Planning Application Ref: BR/258/17/T

Location: Chipley Court, Hawthorn Road, Bognor Regis

Description of works: Fell 1 No Austrian Pine T1 and remove 2 No lower lateral branches on southern side of T2 Austrian Pine and a side reduction of northern crown by 1m to 2.5m.

Location Plan

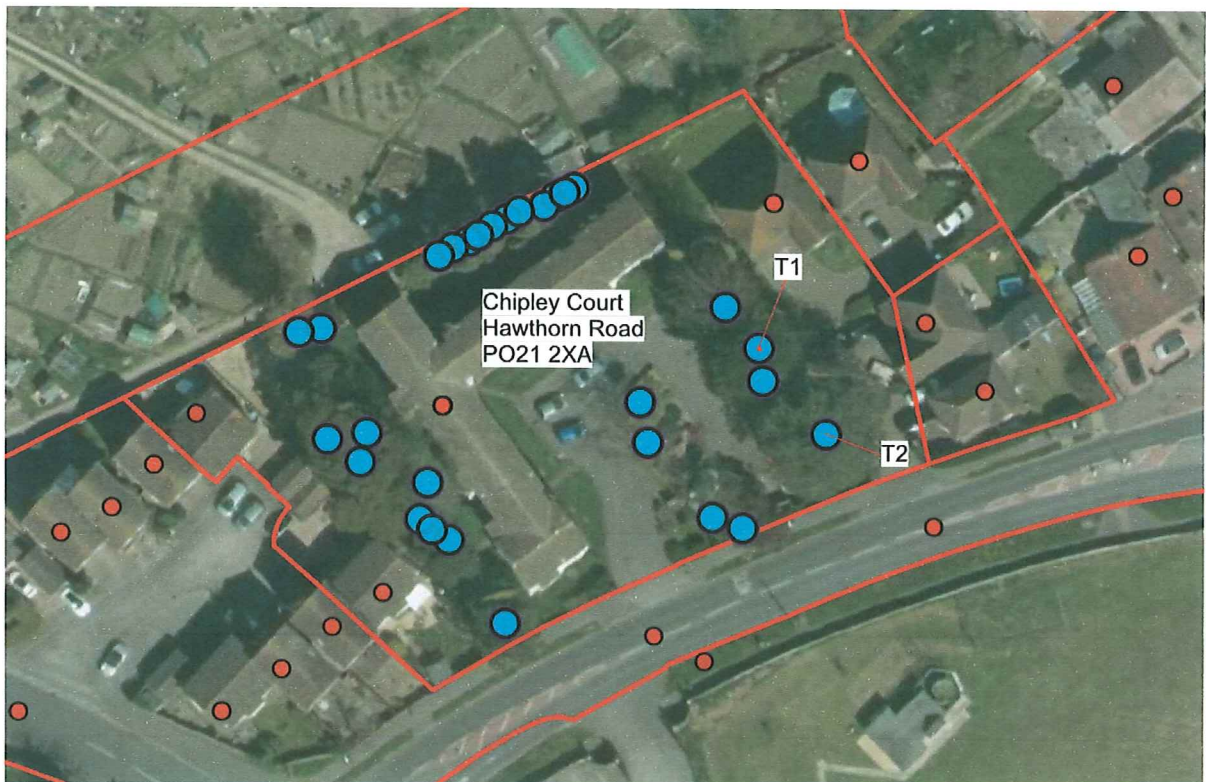
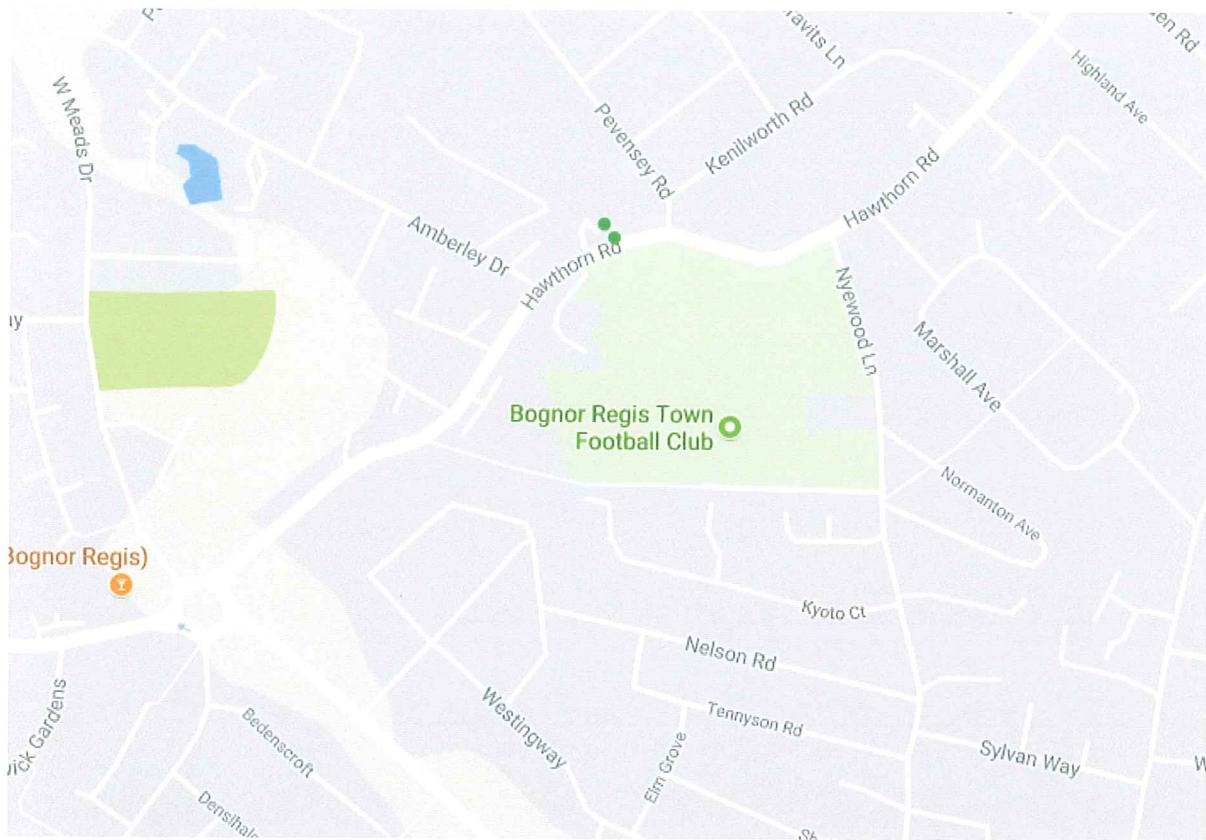
- A healthy tree that has been topped out in the past giving it a multi-stemmed appearance in the upper crown.
- It makes a significant contribution in the landscape and merits its TPO status.
- Significant disruption of the access drives to adjacent properties has been experienced over a long period of time and a permanent solution is sought to this problem.
- Extensive trenching investigation work has been undertaken to the adjacent drives and this has exposed a massing of root just below the surface which comes from this tree.

- A healthy tree that has been topped out in the past giving it a multi-stemmed appearance in the upper crown.
- It makes a significant contribution in the landscape and merits its TPO status.
- Due to competition with other trees the crown has become flattened and grows primarily to the north and south.
- The northern side overhangs the drive to 'The Acorns' and whilst the driveway has suffered only minor lifting of brick setts there is an issue with the needle drop and also cone shedding.

- Pruning the tree has been tried before and this has not prevented this problem and to prune a conifer of this sort to the heavy degree necessary to have any real effect would remove all of the live growth and thus kill the tree.
- To remove the volume of roots found just below the surface would have a significant adverse impact on the vigour and vitality of this tree also allowing access to fungal pathogens through large open wounds.
- Under the circumstances I see no alternative but to allow the removal of this tree to abate the severe nuisance being caused– subject to a replacement being planted of a species which has a less vigorous rooting habit.

- The levels of pruning requested will give a better balance to the crown and also help to abate the nuisance of needle cast and dropping cones.
- None of this work will be to the detriment of the trees visual amenity value or vigour and vitality.

I **APPROVE** of the removal and replacement of **T1 Austrian Pine** subject to the following condition:-

- Once the Pine tree has been removed and ground out then a replacement tree is to be planted 'in the same place'.
- This is to be of Heavy Standard Nursery Stock proportions (12-14cm girth & 3m to 4m overall height) supported on a 'short stake' system with appropriate securing ties and pads.
- It is to be planted within 12 months of the removal of the Pine tree.
- The species shall be selected from the following:-
Foxglove Tree - *Paulownia tomentosa*
Dawn Redwood – *Metasequoia glyptostroboides*
Tupelo – *Nyssa sylvatica*
